Please ask for: Sian Eggington
Email: sian.eggington@terraquest.co.uk
Telephone: 0121 2341390
Our Ref: LU/82/21/HH
Your Ref:
Date: 19th March 2021

Application for Planning Permission for Works or Extension to a Dwelling

Development: Erect a new garage as a continuation of the north eastern projection.
Convert existing garage to a home office, utility and shower room.

Location: 101 Griffin Crescent Littlehampton BN17 7LH

Firm Name and Address
PROPOSED ELEVATIONS

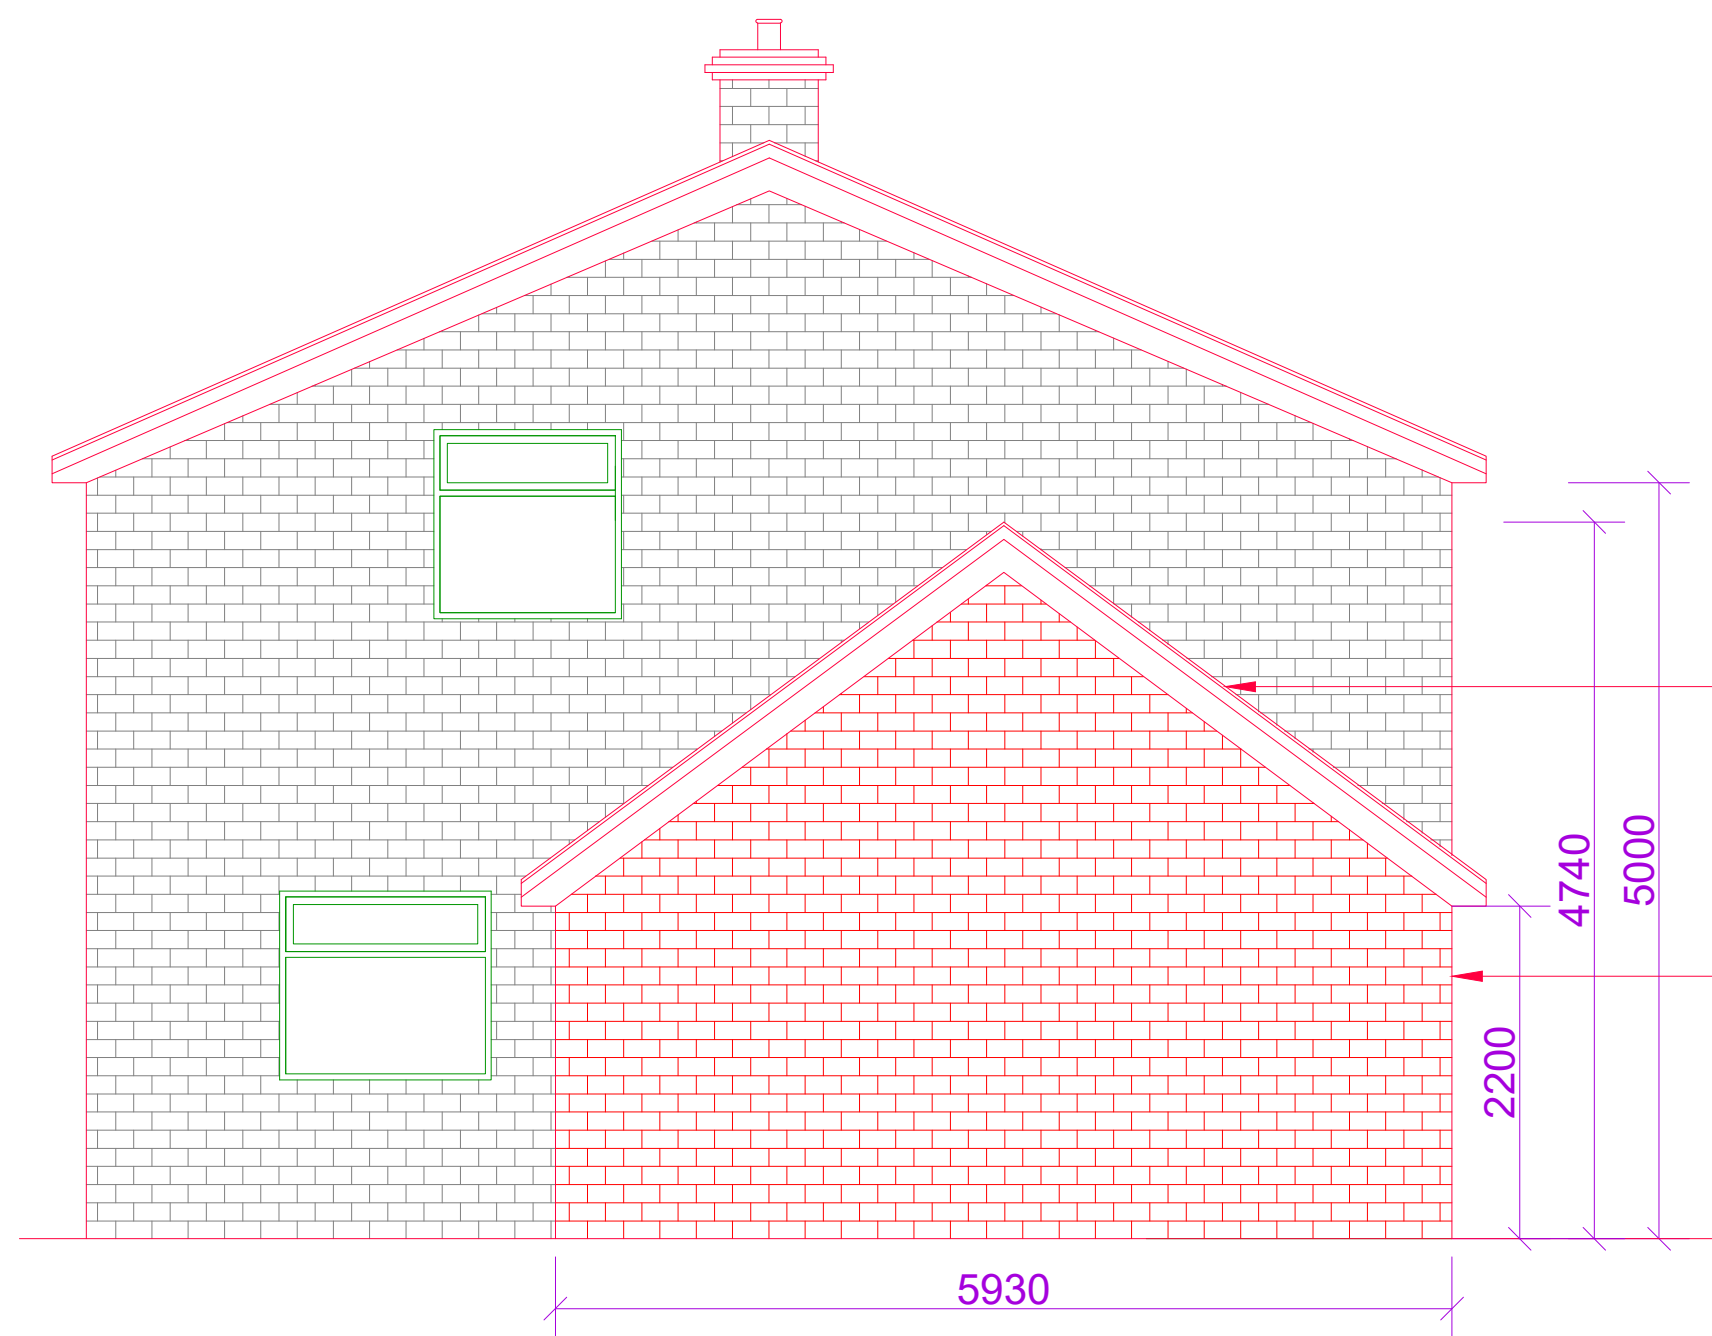
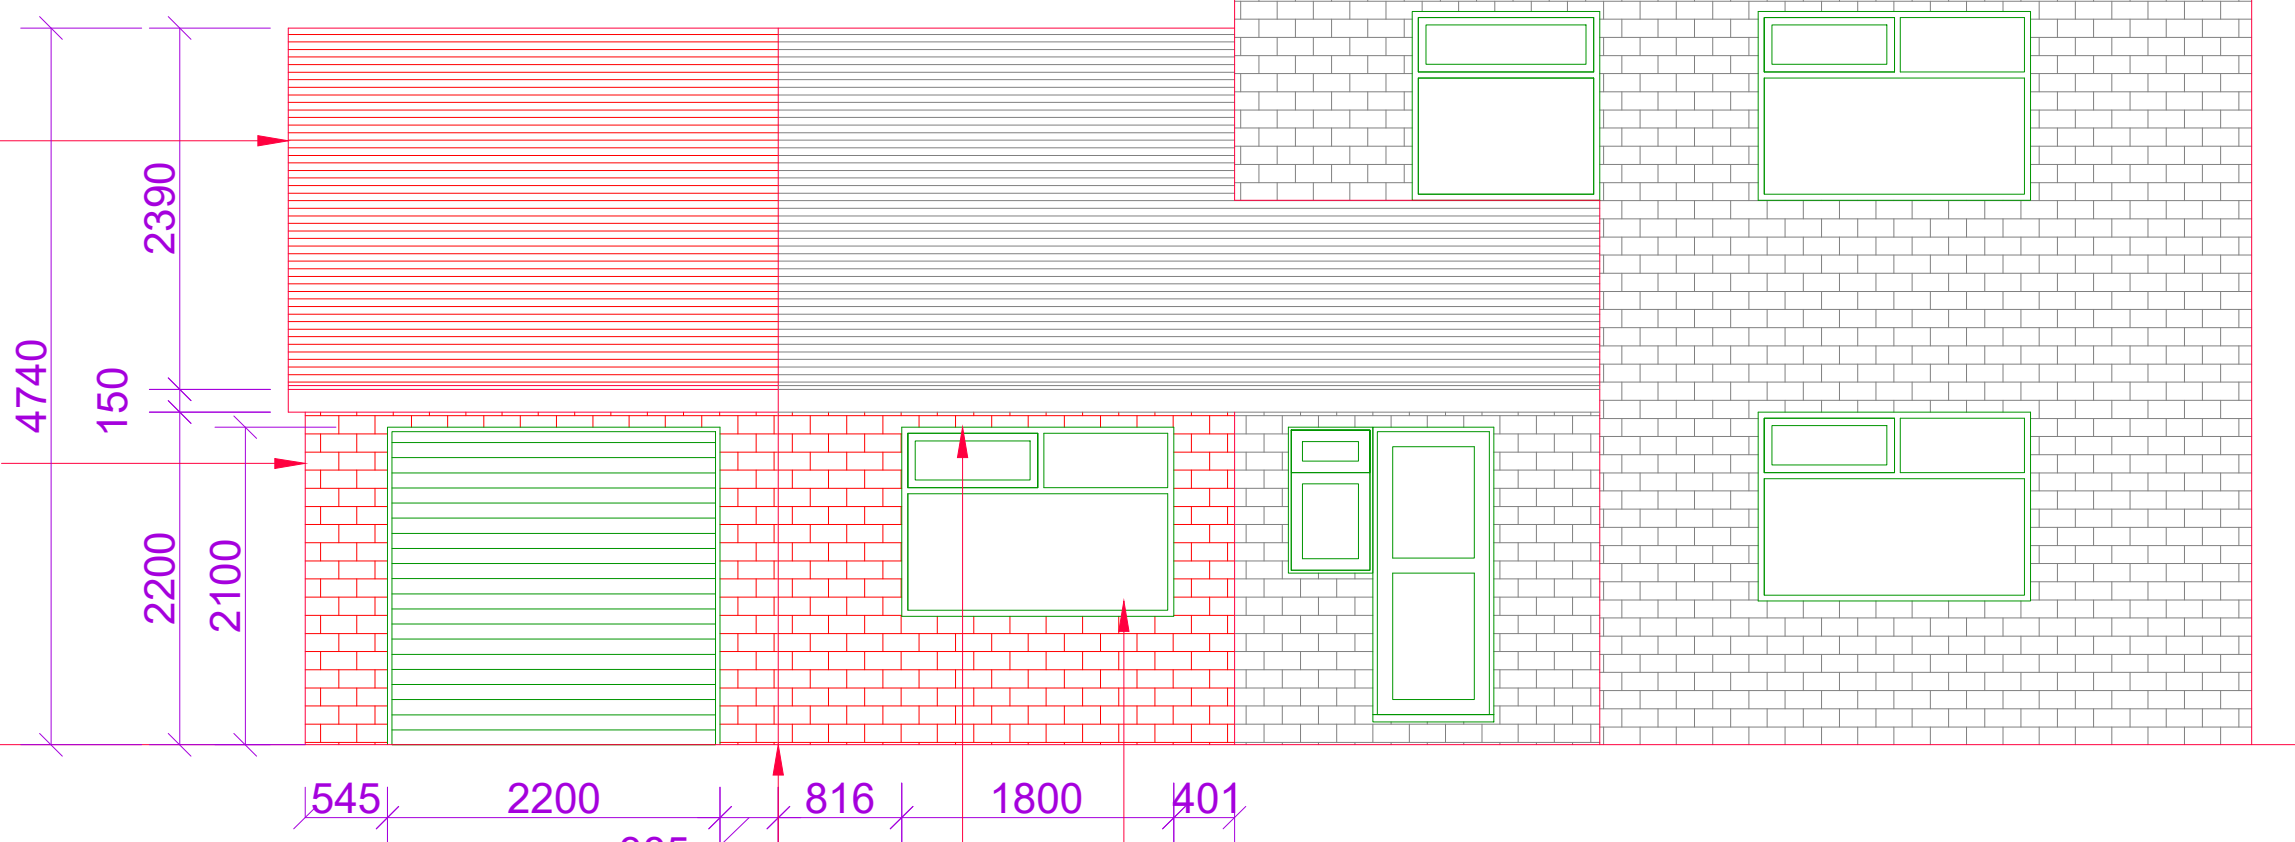
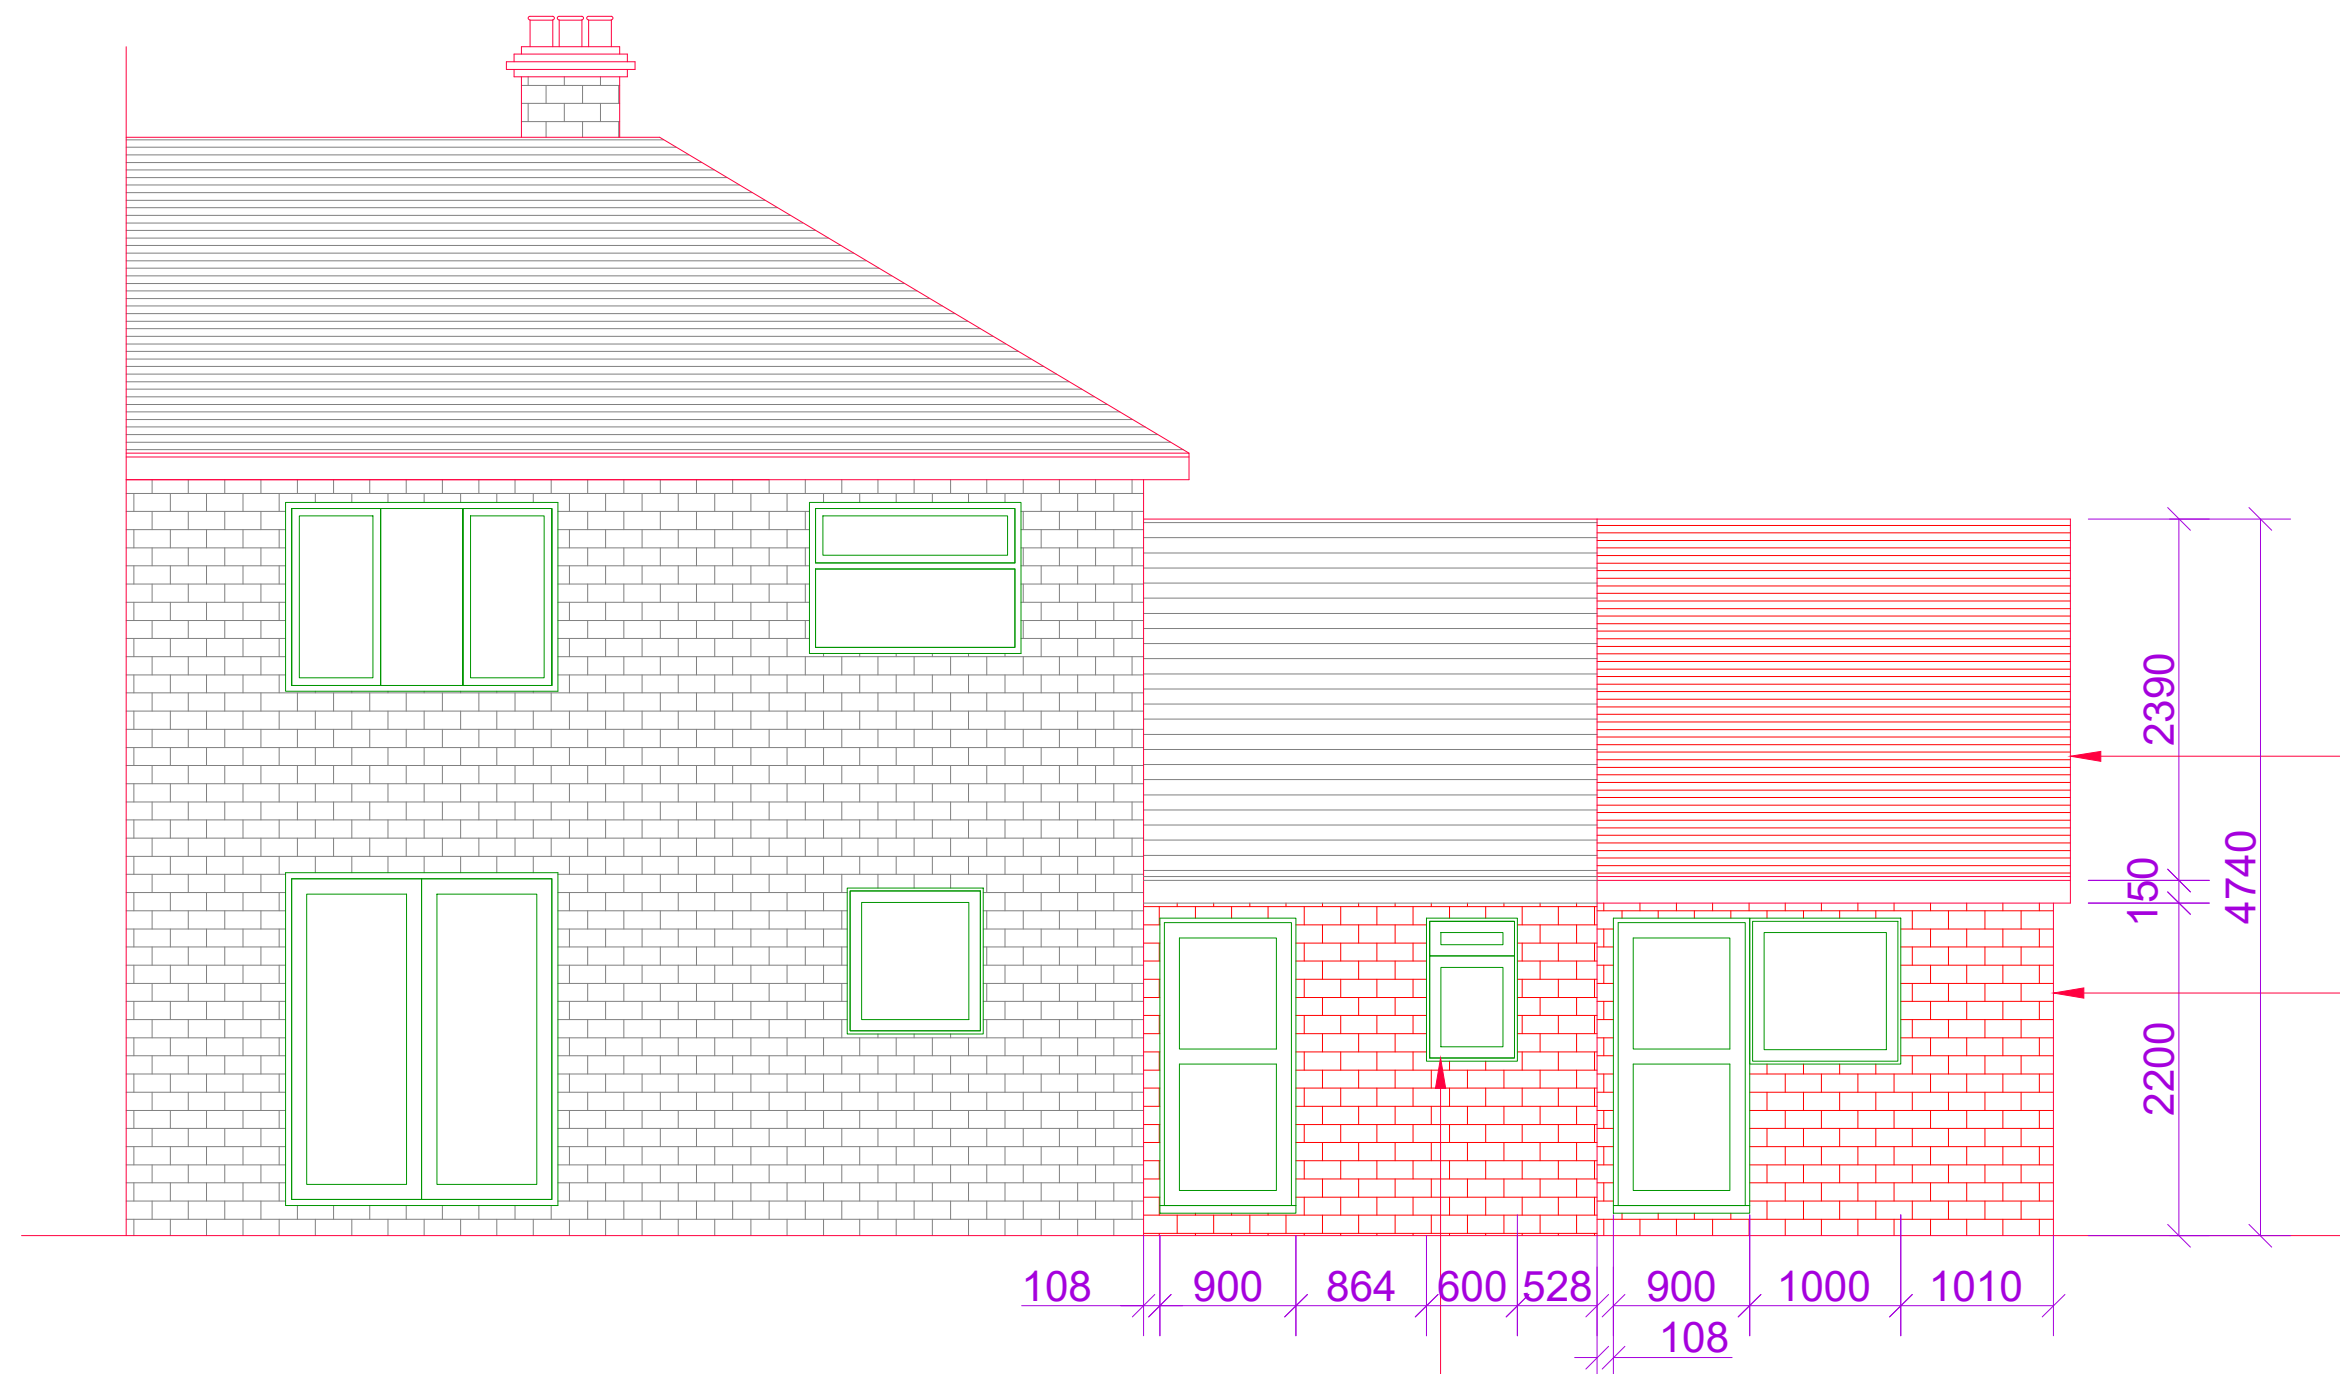
Elevations

Please submit a copy of clearly labelled existing and proposed elevations at a scale of 1:50 or 1:100. Further details can be found in the Validation Requirements List.
